Re: Proposed Wind Energy Development by Ballinlee Green Energy Ltd. – Observation under Section 37E / Planning & Development Act 2000 (Case Number :PAX91.323780)

We, Sarah Clifford and George Shinnors, write in our capacity as residents of Crean, Bruff, Co.Limerick, V35PD72. Our home is located within 1km of the proposed development by Ballinlee Green Energy Ltd. Case number 323780. We submit this observation to draw attention to our concerns regarding the proposal and to request that An Bord Pleanála give full consideration to the issues outlined herein.

Figure 3-12: Final Site Layout

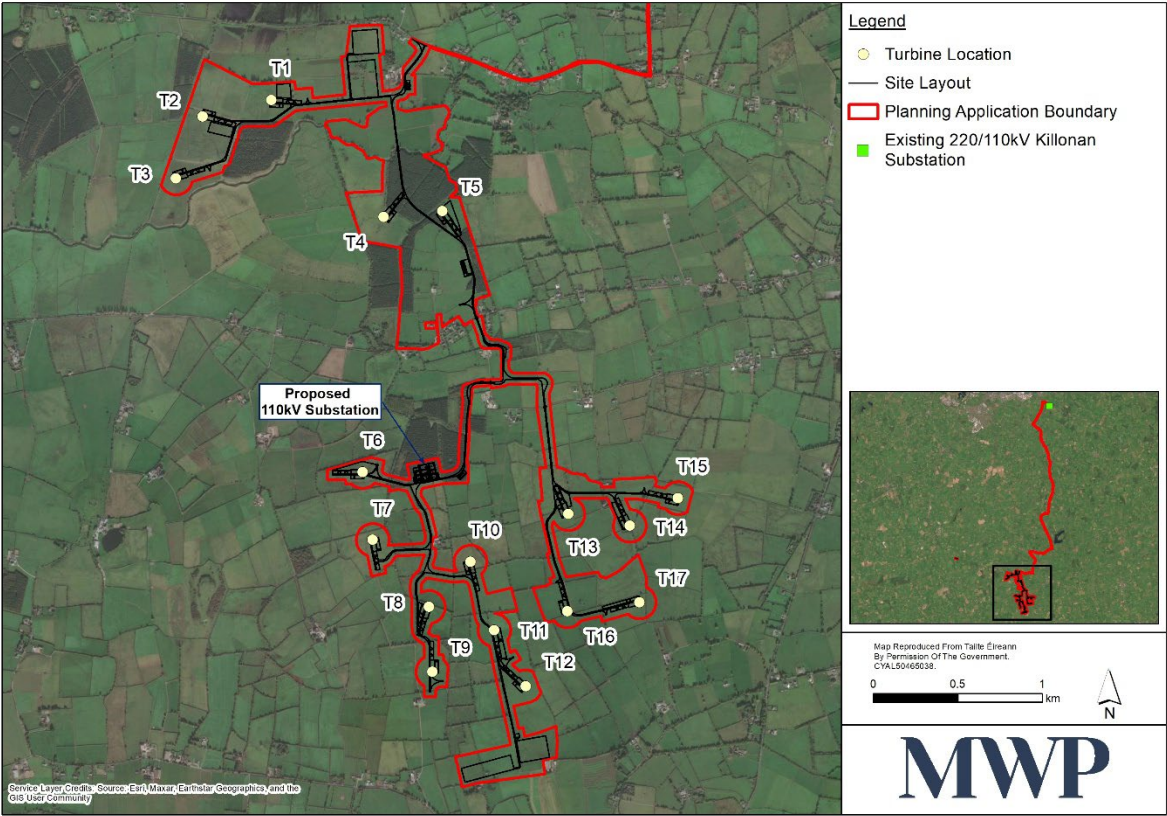
- The above 2 photographs were taken on the morning of the 16/11/25. Circled in black is a single Whooper Swan flying in the direction of where T1 and T2 are to be located.
- The land where T1, T2 and T3 are located is subject to flooding every year and sometimes up to 3-6 months of the year. This draws flocks of swans, geese, herons and seagulls. We are significantly concerned about the impact this will have on those populations.

- Significant concern about the impact of excavation will have on flooding levels in our local area. Specifically, the area where wind turbines T1, T2 and T3 are proposed to be located. This area experiences regular flooding, especially during the winter months as demonstrated in the above pictures.
- The R512 from House 9 towards Bruff is subject to sinking and the road level becomes uneven very quickly due to subsidence. Road maintenance works are carried out every number of years. We feel the increased traffic at construction and maintenance phase will have a negative effect on this already vulnerable stretch of road.

- Please assess the landscape where T1,2, and 3 are proposed as it is subject to flooding . We propose that T1,2 and 3 do not get planning permission as this will worsen the flooding of this area. Potentially consider could they be located in an area elsewhere on that landholding.

Figure 15-3: Wind Turbine and Dwelling Locations

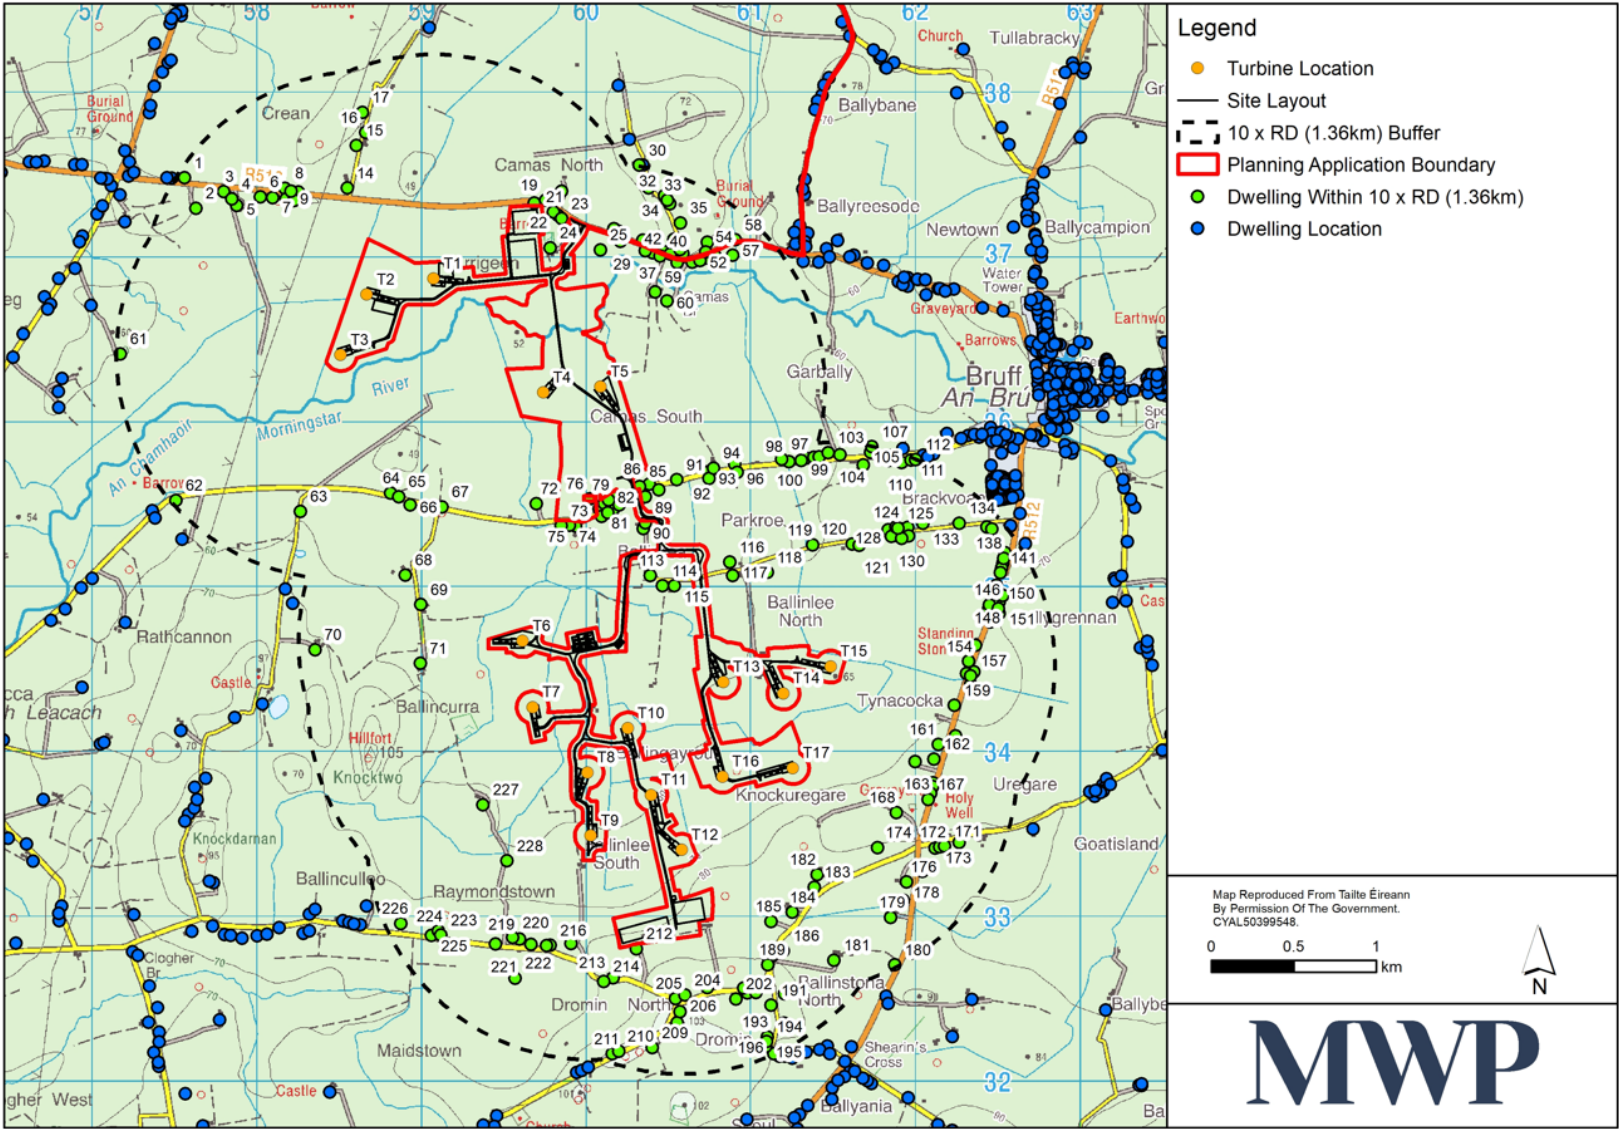
- Our house is dwelling No. 6. shown above in green.

- As you can see from the table. The maximum days per year affected might be 138 and maximum minutes per day might be 39.
- We believe that the development should not go ahead given the proposal breaches these guidelines for our property, as clearly stated in the application. If the permission goes ahead An Bord Pleanála need to make it a condition of the planning permission that the developers needs to endeavour to commit to install mitigation measures that will eliminate shadow flicker in line with the draft 2019 guidelines.

- Landscape, visual and amenity impacts—particularly our local views, community character and property. Specifically related to shadow-flicker as outlined above exceeds the 2006 guidelines. Again, T1, T2 and T3 not to get planning permission where they are currently proposed or to consider changing the location to another area within that landholding where this would eliminate shadow-flicker on our property.

Figure 4. Projected flight lines from VP surveys illustrating SW-NE trend and the proposed enhancement area. KDE isopleth bands are used as a swan-day index for levels of site use with opacity increasing with intensity of use (1-25%, 25-50%, 50-75%, > 75%) as in Figure 3.

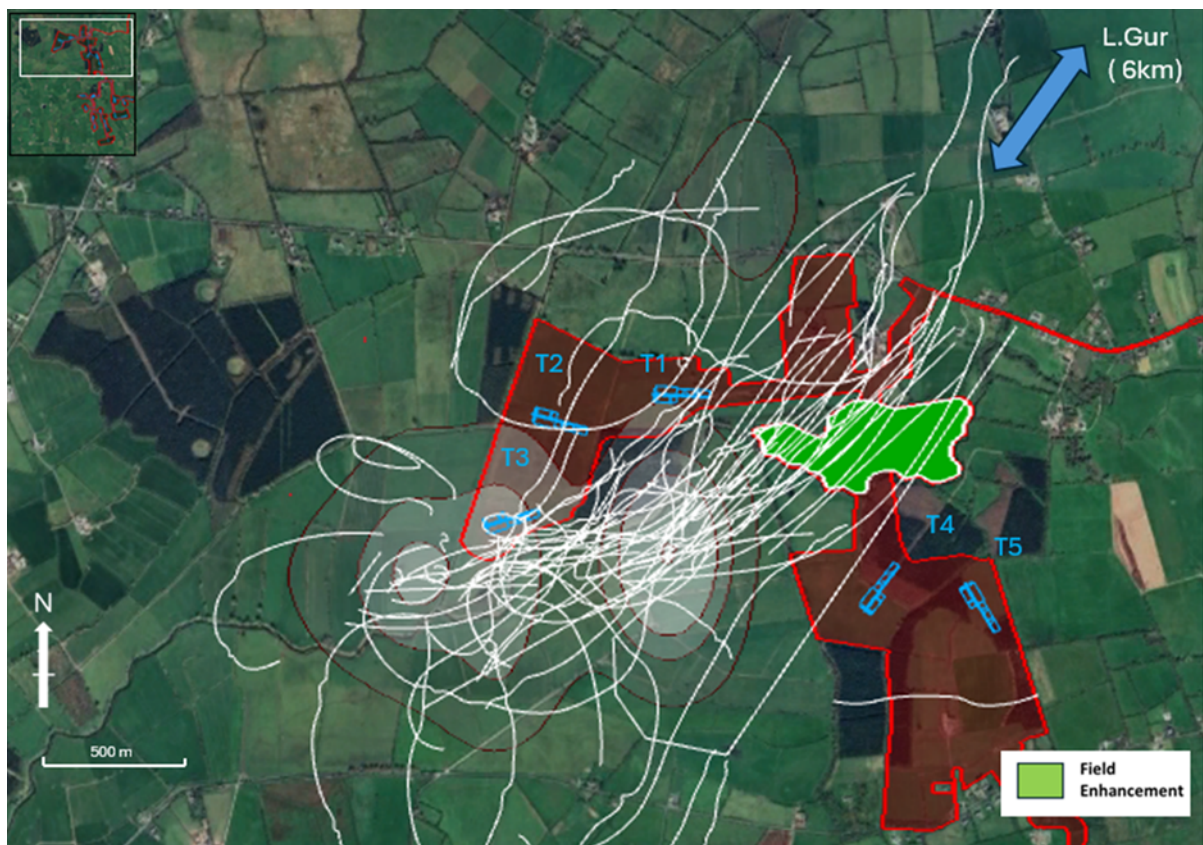
- Specifically, regarding the Whooper swan which migrates here every year, we have concerns that the specified mitigating factors are not sufficient to protect this species.
